Application Reference: 2026/0535

Site Address: Hudroyd House, Genn Lane, Ward Green, Barnsley, S70 6NW

This application seeks full planning permission for the erection of extension to existing detached garage and replacement of flat roof with pitched roof (retrospective)

Ground Floor Layout
as Proposed.

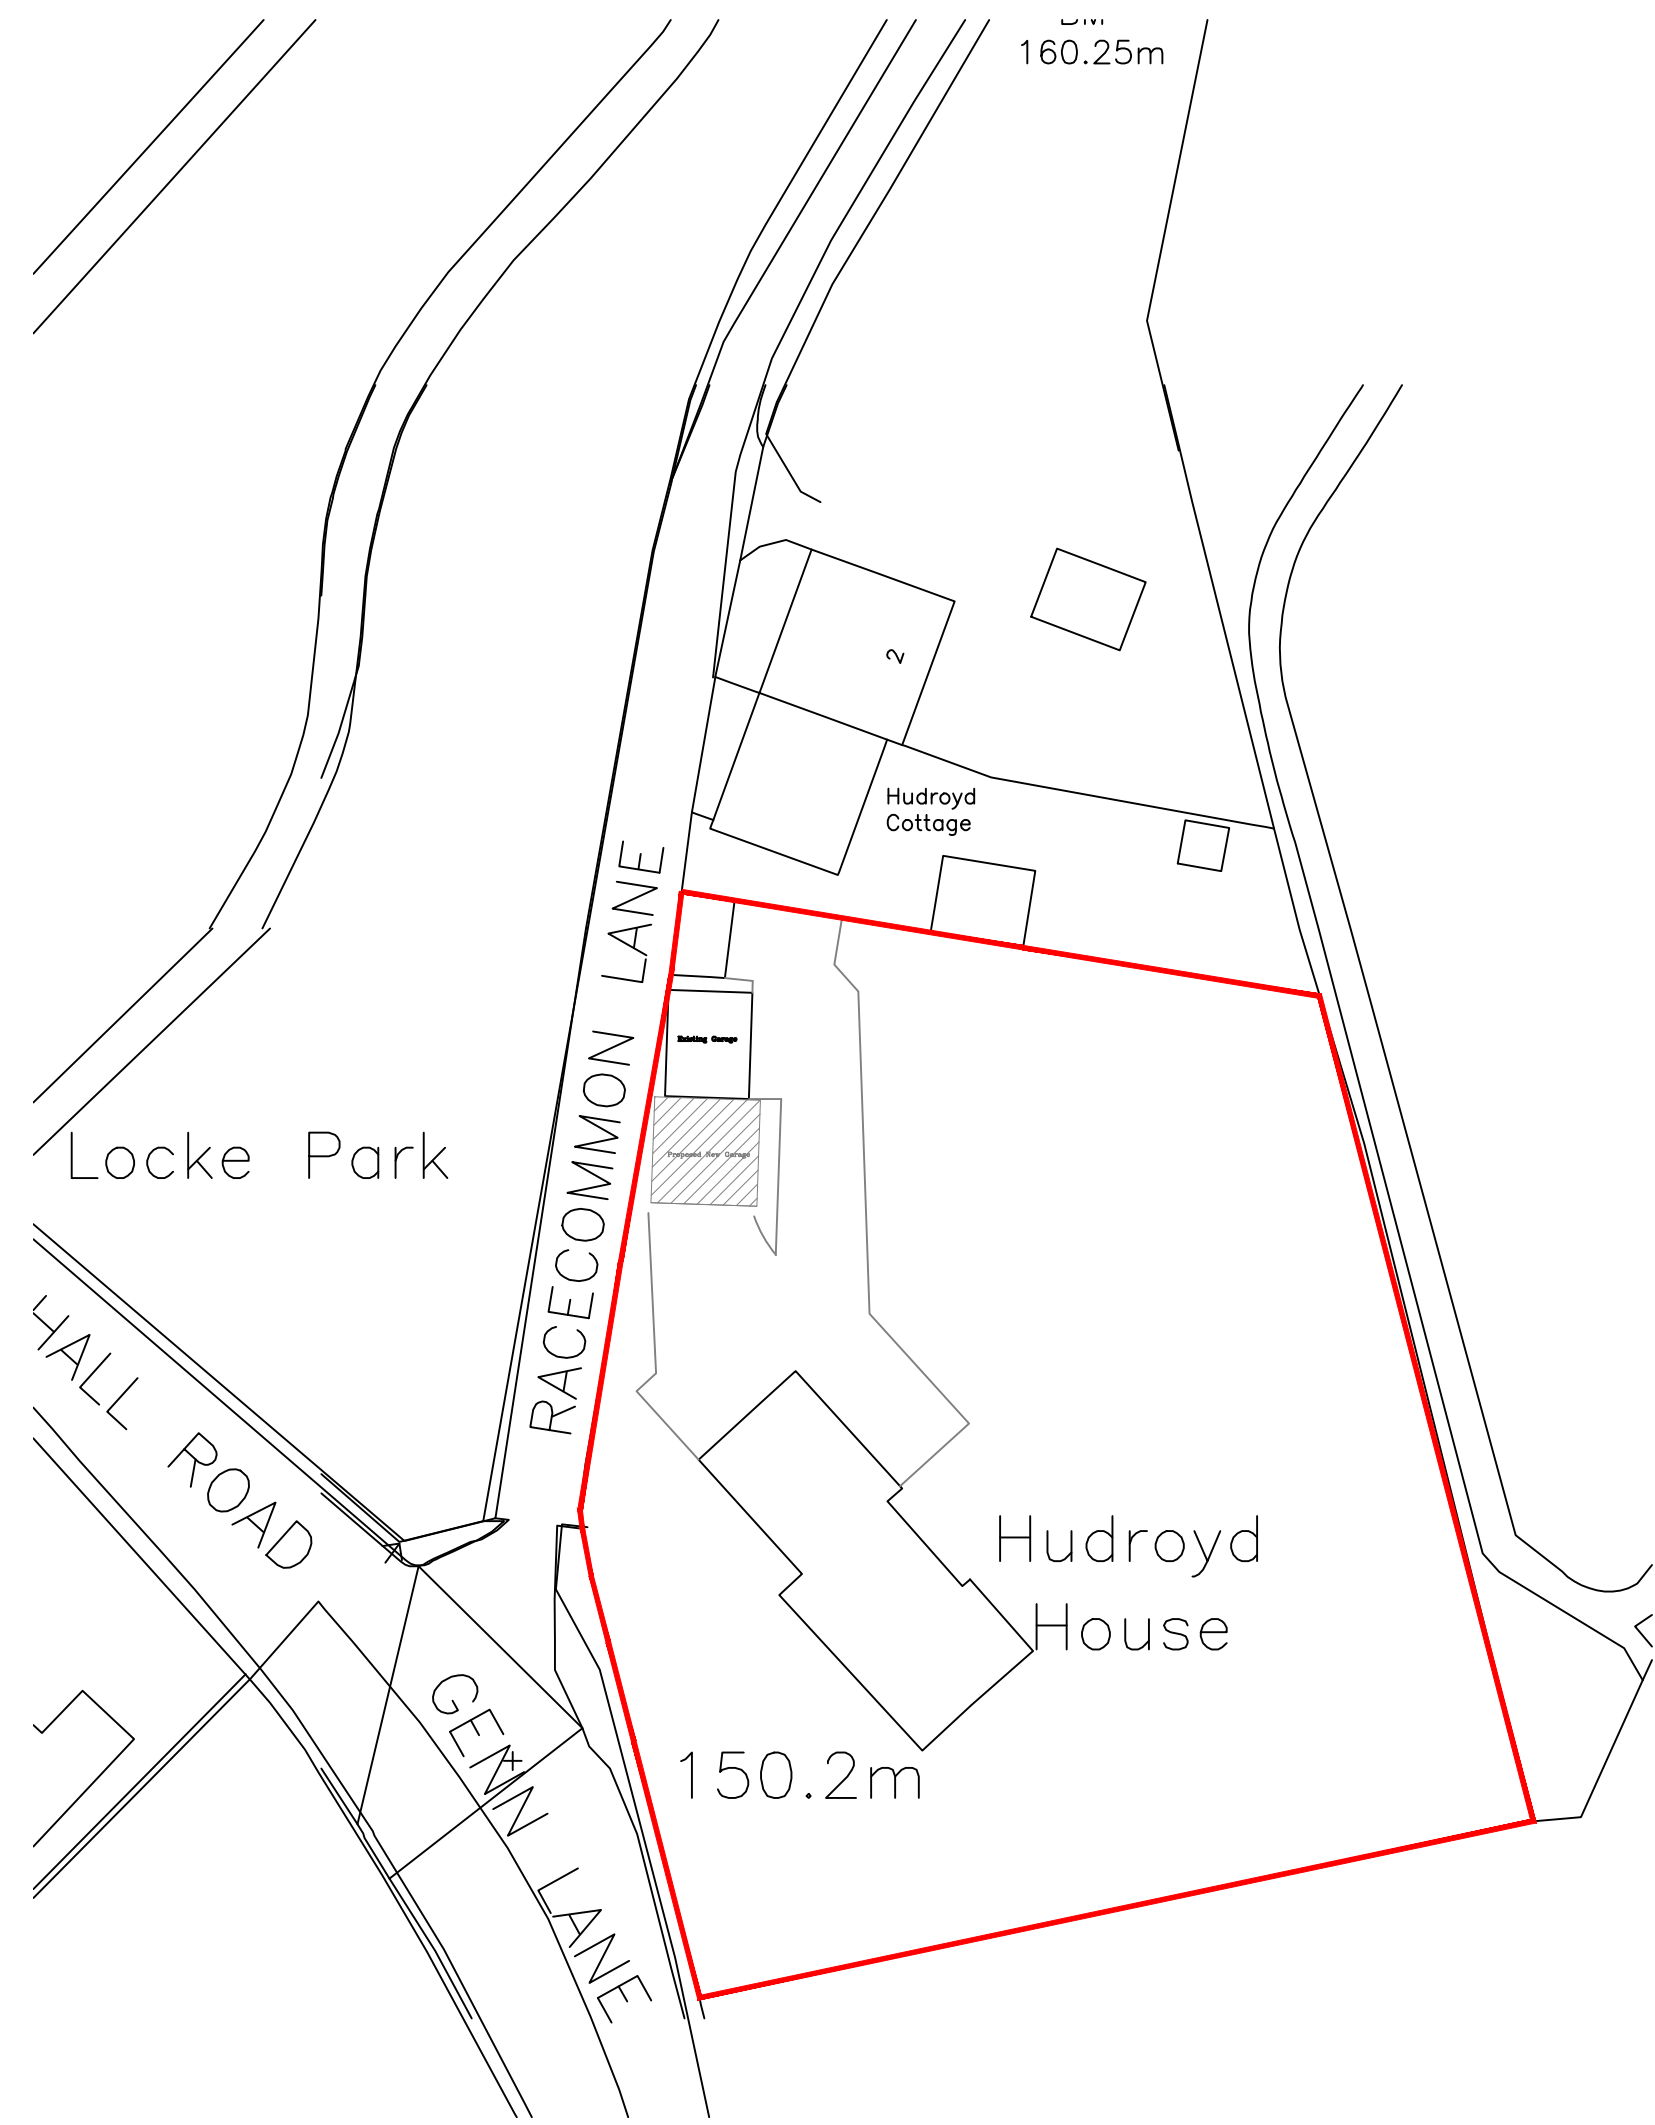
The application relates to the erection of an extension to the existing detached garage and the installation of a pitched roof. The extension is proposed on the southern elevation of the existing garage and would not result in any material increase in overshadowing, overlooking or loss of outlook to neighbouring dwellings. The principal matter for consideration, and the issue raised in representations, relates to the increase in the roof height compared to that approved under application 2026/0045.

Whilst the outbuilding is situated to the south of the closest neighbouring dwelling, 1 Hudroyd Cottages, it is located within its building line and does not project beyond it. Although the ridge height would increase by approximately 2m compared to the previously approved scheme, the building remains detached from neighbouring dwellings and is separated from the neighbouring property by the respective driveways serving both sites. The outbuilding would be positioned approximately 6.3m from the shared side boundary and approximately 10m from the side elevation of the neighbouring dwelling. Consequently, any additional shadowing associated with the increased roof height would largely fall across these intervening areas rather than directly affecting the neighbouring dwelling or its principal amenity space.

Concern has also been raised regarding overlooking from the proposed first-floor playroom. It is acknowledged that a window is proposed at first-floor level; however, this opening would be located within the southern elevation and would face back into the application site and away from neighbouring dwellings. The proposed rooflights would be positioned within the western roof slope and similarly would not provide direct views towards neighbouring habitable room windows or private garden areas. The proposal would therefore not result in any material increase in overlooking or loss of privacy. This carries limited weight against the application.

Comments have also been made regarding potential glare arising from the proposed solar panels on the eastern roof slope. Whilst these concerns are acknowledged, there is no substantive evidence to demonstrate that the proposed panels would result in significant harm to neighbouring occupiers through reflected glare. Solar Panels can be installed without planning permission, and national planning policy provides strong support for renewable and low-carbon energy technologies and for measures that improve the energy efficiency of existing buildings. NPPF National Decision-Making Policy CC2 states that substantial weight should be given to the benefits of improving the energy efficiency of existing buildings by drawing energy from renewable and low-carbon sources, including solar panels. Consequently, this matter carries limited weight against the development, whilst the environmental benefits attract substantial weight in favour of the proposal.
